Recommendation Report for Planning Permission

REF NO: BN/75/19/PL

LOCATION: Land adjacent to Cherry Trees
Lake Lane
Barnham
PO22 0AD

PROPOSAL: 1 No. dwelling & associated works.

SITE PLAN  
1-200.

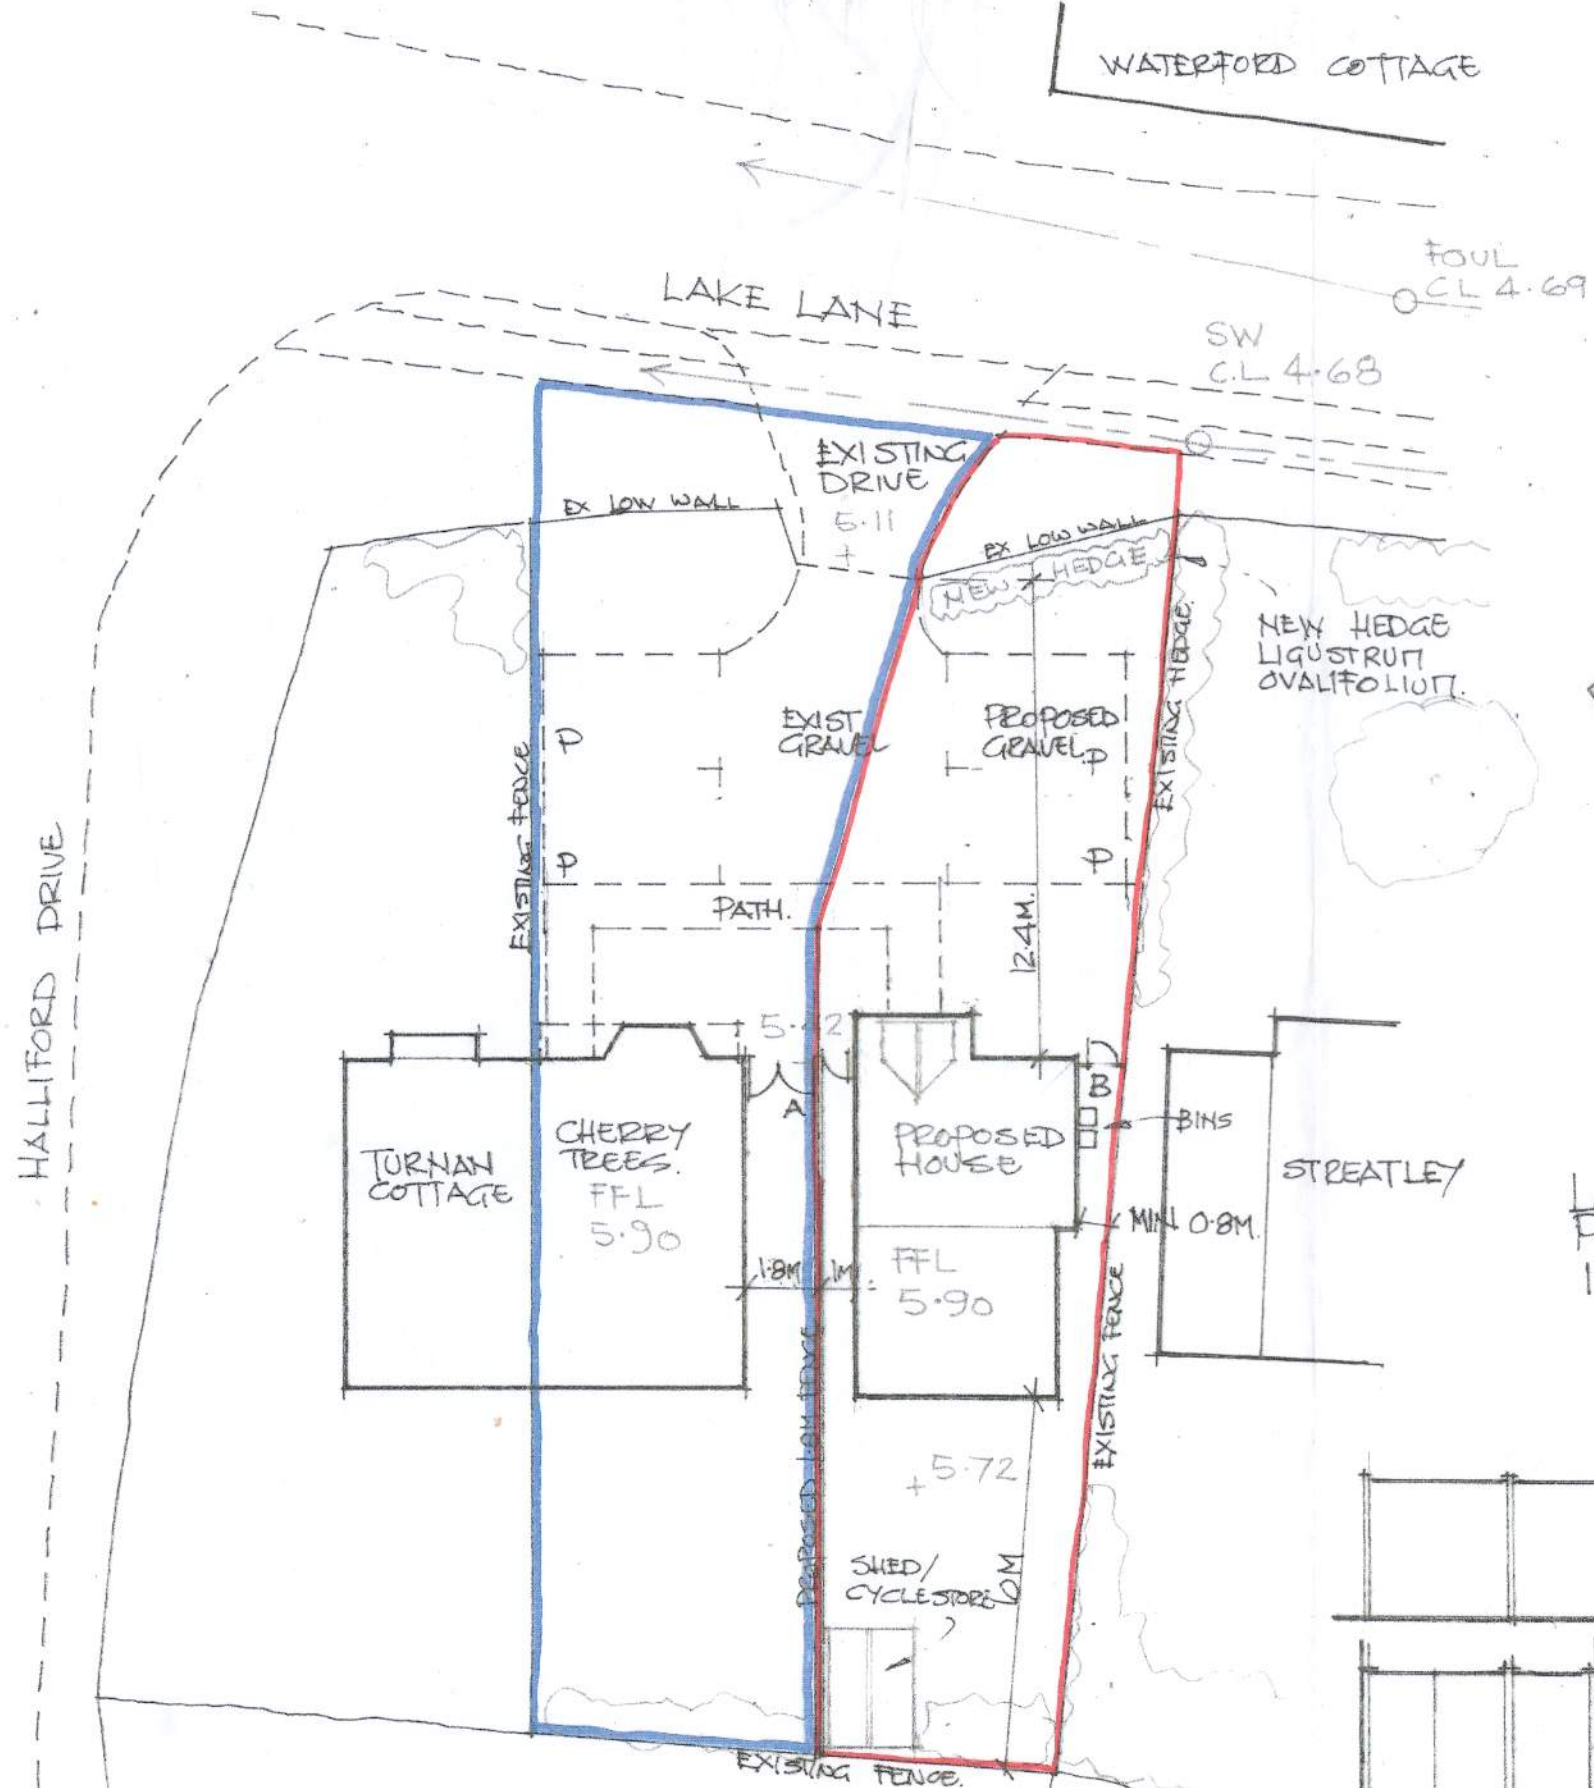
The size of the site is small but there are other similarly sized sites in the surrounding area. The dwelling would be positioned in an existing garden area between Cherry Trees and Deep End. A distance of 0.8m is kept to the north-eastern boundary and a distance of 1m is kept to the south-eastern boundary which allows space for bin and bike storage at rear. This space is minimal but again not uncommon in the nearby area. From a streetscene perspective the proposed would have a similar width, height and roof form as some other nearby dwellings. As a result the development would be in keeping with the general pattern and scale of development in the locality.

This rear garden would be 6m in depth and 5m in width which does not comply with Policy D DM3 which seeks to provide 85sqm of private amenity space.

PLANS
ELEVATIONS
STREET SCENE
JULY 2019
DRAWING 2.
SCALES AS SHOWN (A3)

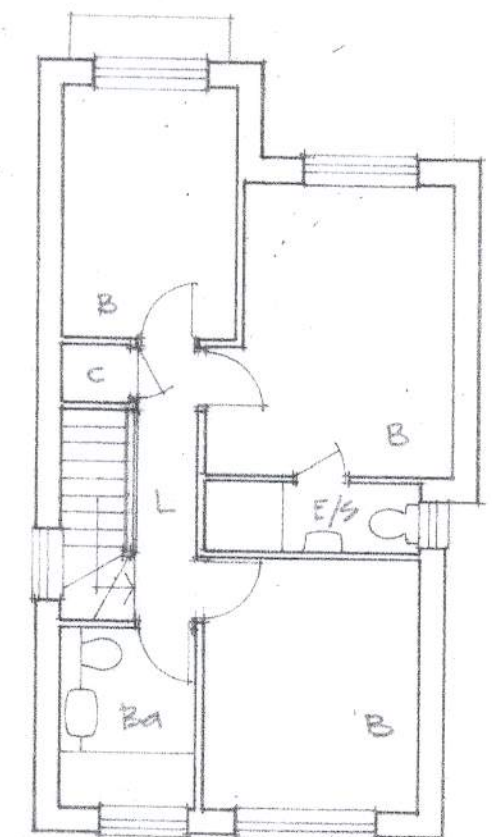
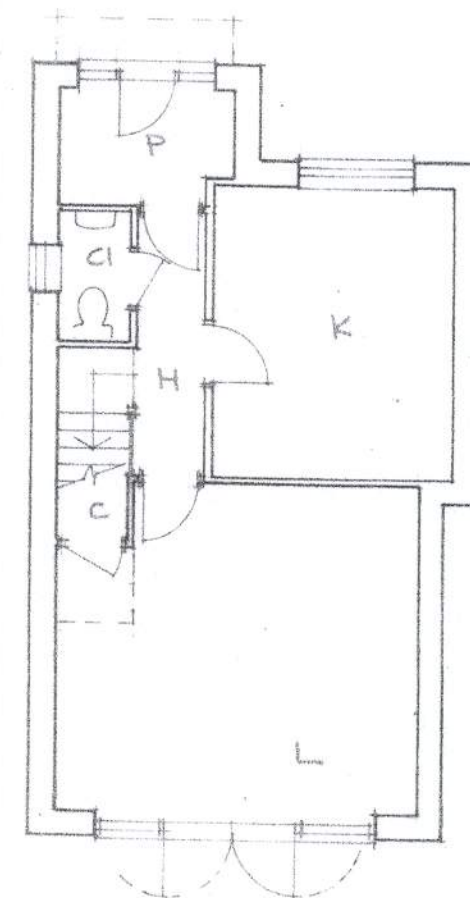
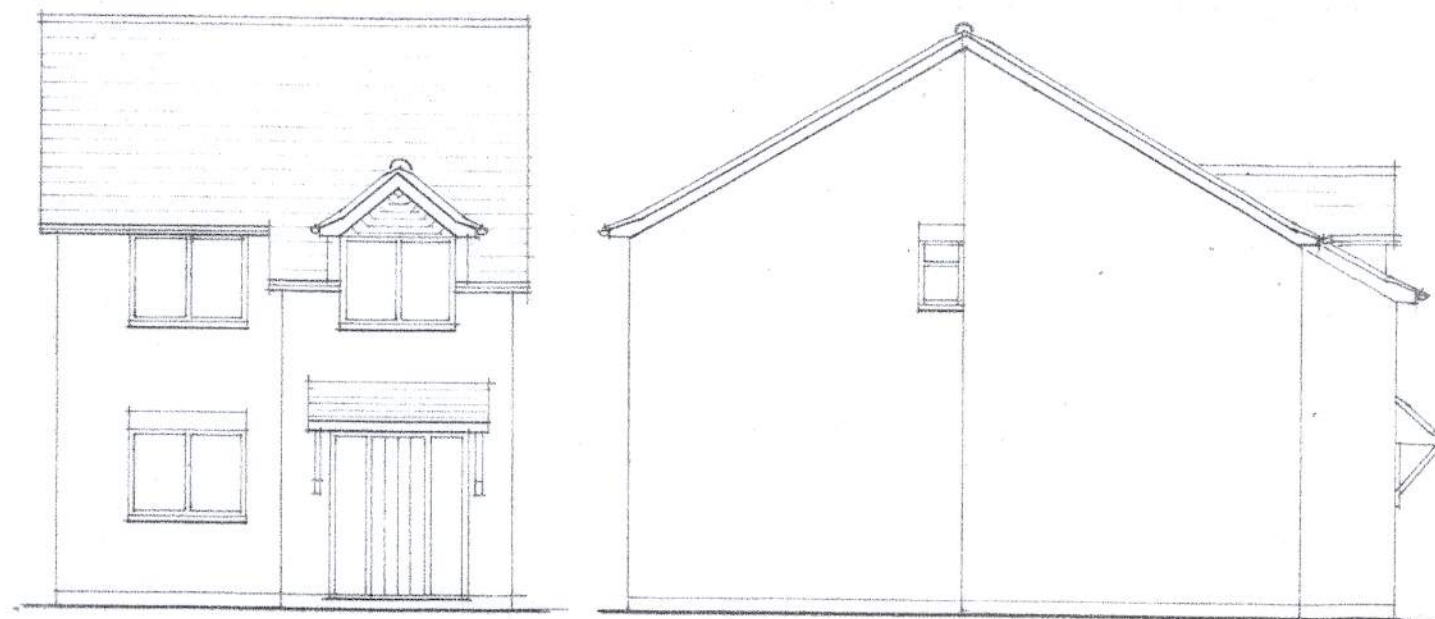
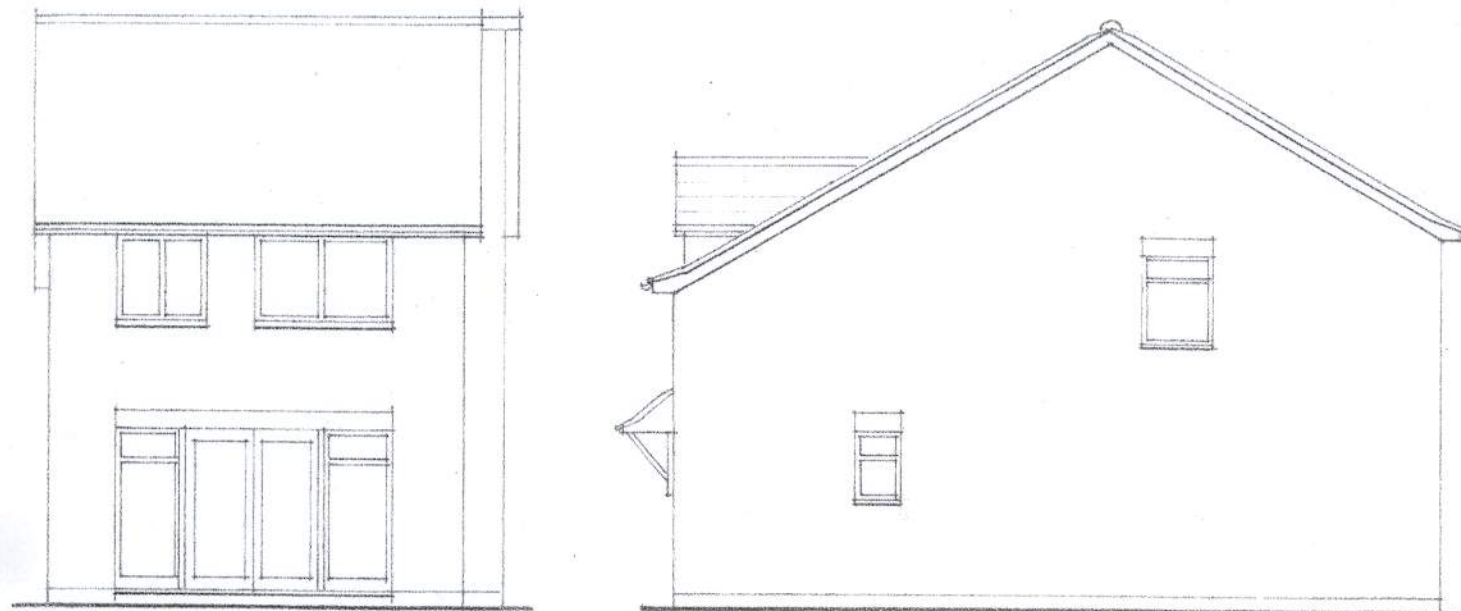
The front facing dormer window in the proposed dwelling would face onto Lake Lane and the dwelling opposite, 'Timbers', where privacy would not be significantly affected due to the distance involved. Two side facing windows are proposed for the south-eastern elevation, one would be for a 1st floor landing area and the other would be for a ground floor bathroom. This ground floor bathroom window would be obscure glazed by condition if approval was granted and the landing area is not a habitable room thereby limiting any potential overlooking of Cherry Trees. One window is proposed for the north-eastern elevation and this would be for a bathroom window which would also be obscure glazed by condition, if permission was granted.

In terms of any other overlooking the proposal would be approx. 10m from its nearest neighbour to the rear No. 1 'The Heathers'. This distance is not sufficient to prevent overlooking even with the existing boundary conditions at rear. A distance of approx. 23m is encouraged between proposed rear elevations and neighbours at the rear.

The site and this proposal would provide an inadequate living environment for future occupiers. Inadequate amenity space would be provided in the rear garden and the development would also result

an inadequate amenity space for the rear garden of Cherry Trees.

- 2 The development is likely to give rise to direct overlooking of neighbouring properties to the rear to the detriment of the amenities of the occupants of these properties in conflict with policies D DM1 of the Arun Local Plan.
